Our Ref: LU/276/20/HH

Thank you for your letter and for clarifying that the extension approved under LU/334//19/HH has been built and that you are proposing further changes to the extension.

EXISTING FLOOR PLANS

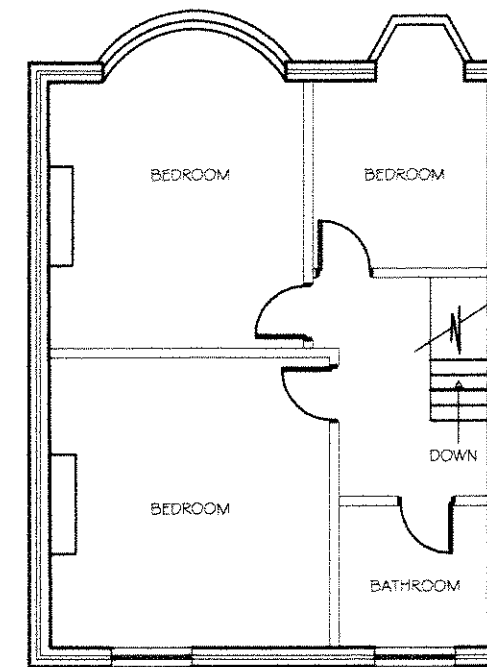
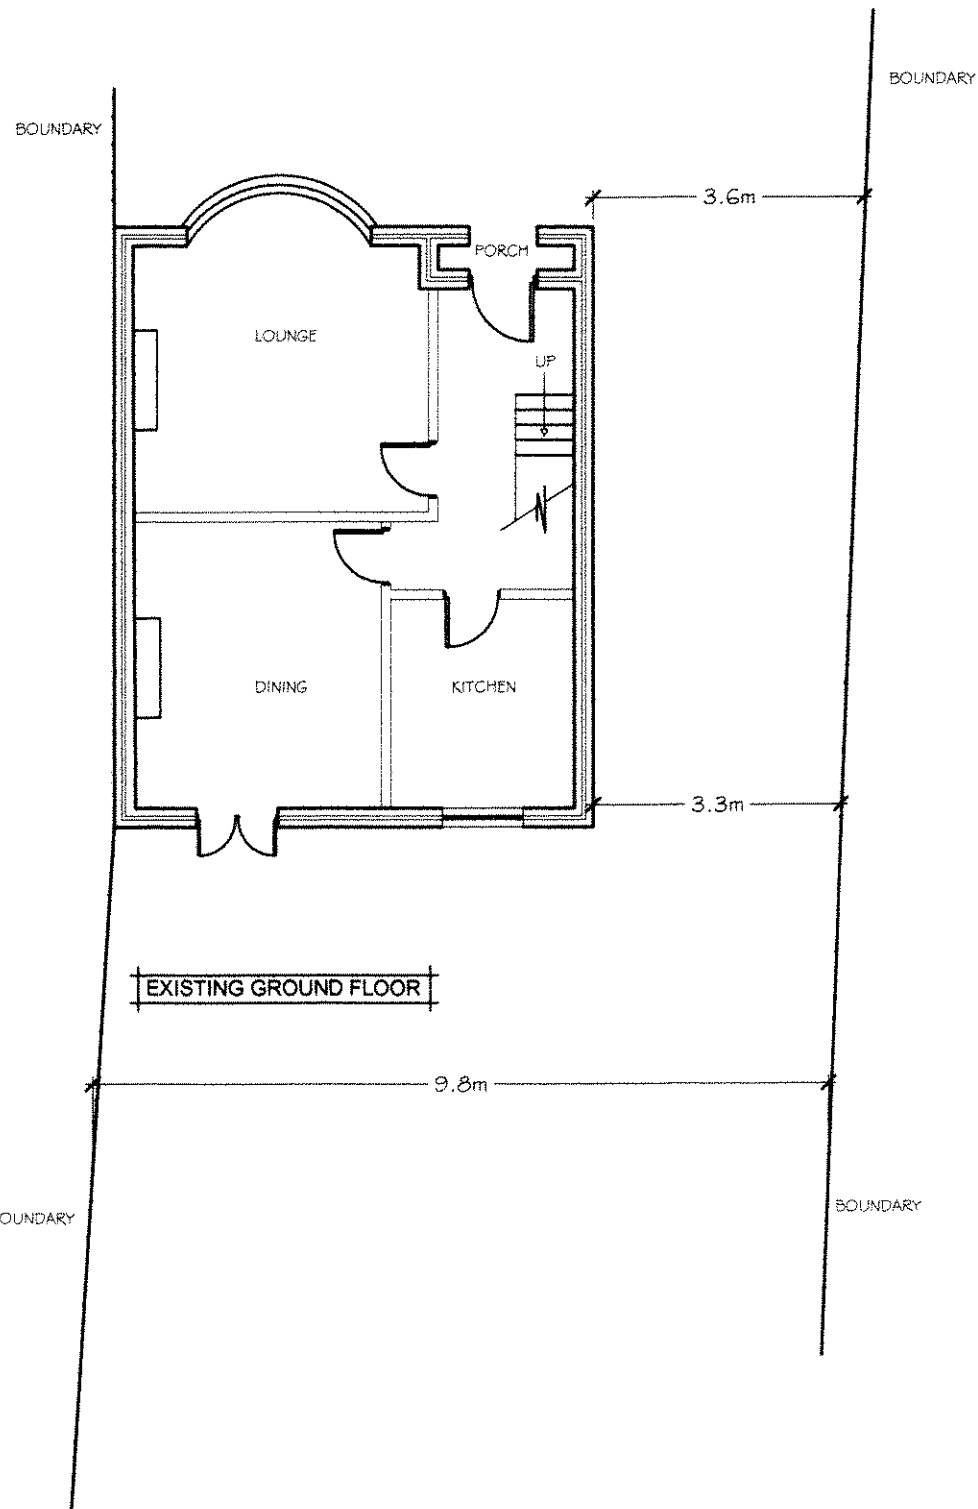
However now that I have understood that the extension approved under LU/334/19/HH has been built I have realised that the existing floor plans provided on this application are not correct as they reflect the position prior to the extension being built. The existing floor plans must reflect what is on site now. I note that you provided 3 sets of elevations plans (the existing pre-extension, existing as now showing the built extension and the proposed elevation plans) so you may wish to do the same for the floor plans or you may wish to just provide the existing as now. We only require the existing as now.

PROPOSED SOUTH ELEVATION

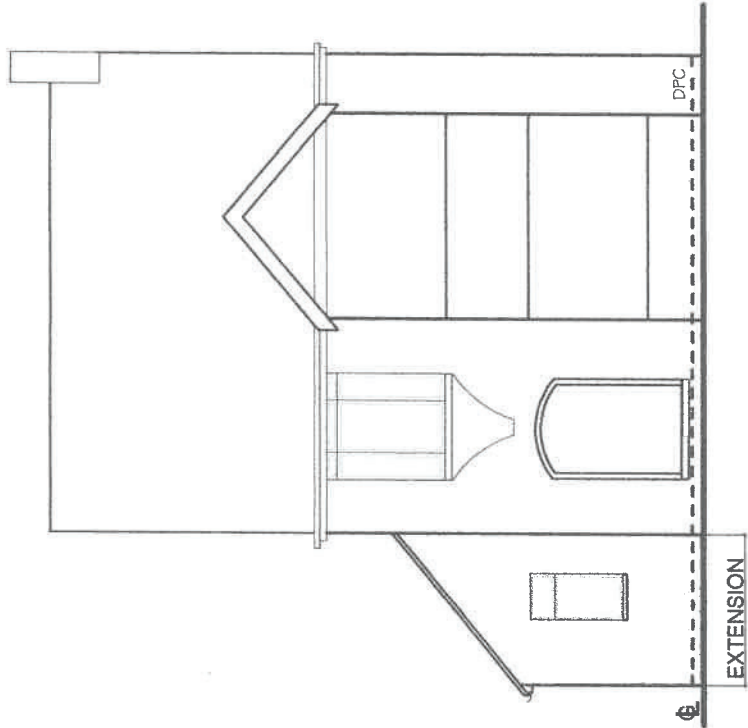
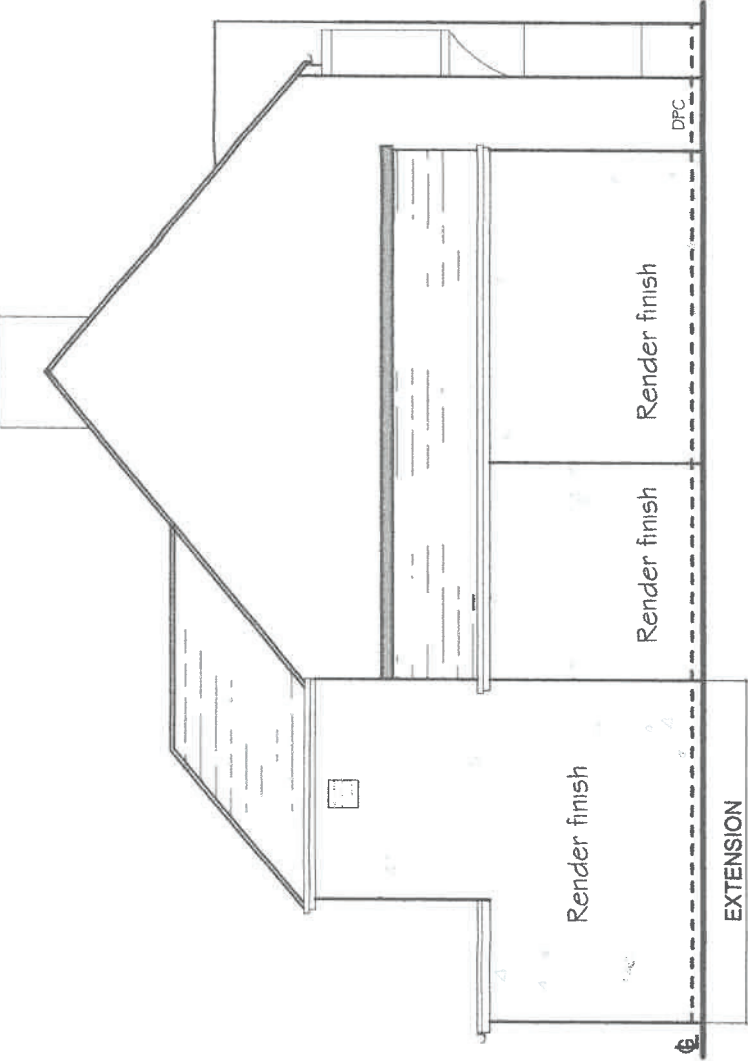
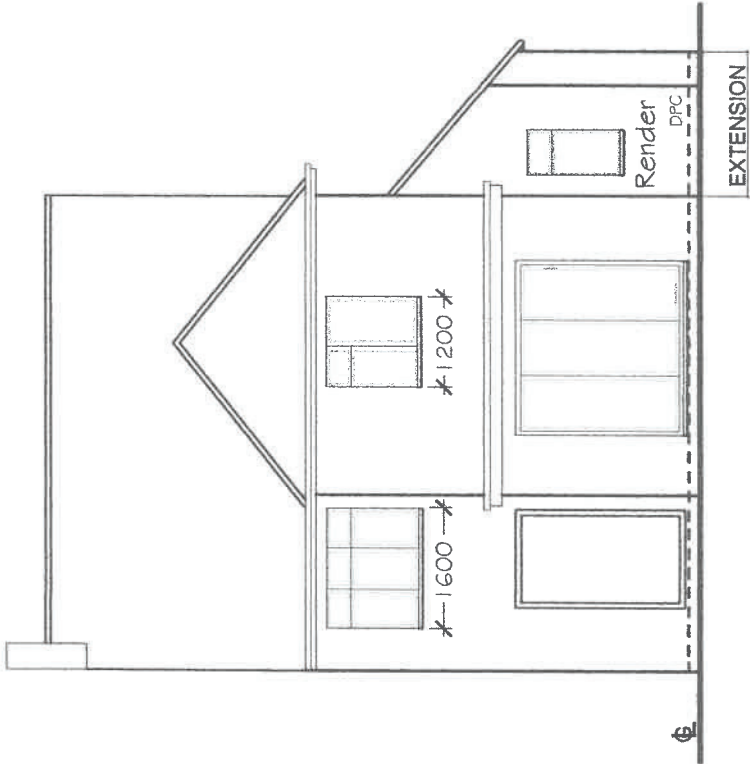
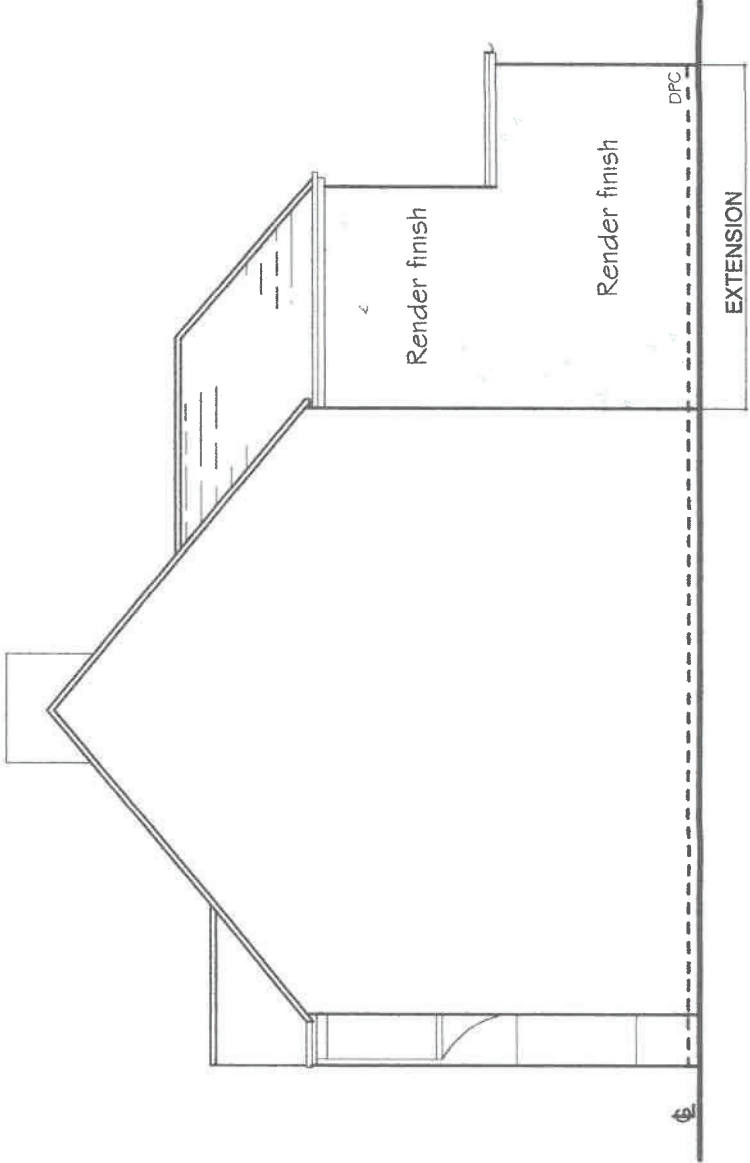
- The planning fee of £206.00
- The need for the proposed floor plans and elevations to match in particular in relation to the first floor window on the South Elevation
- The distances to the boundary need to be shown on the block plan
- A completed CIL Form 1 Additional Information form which I provided previously.
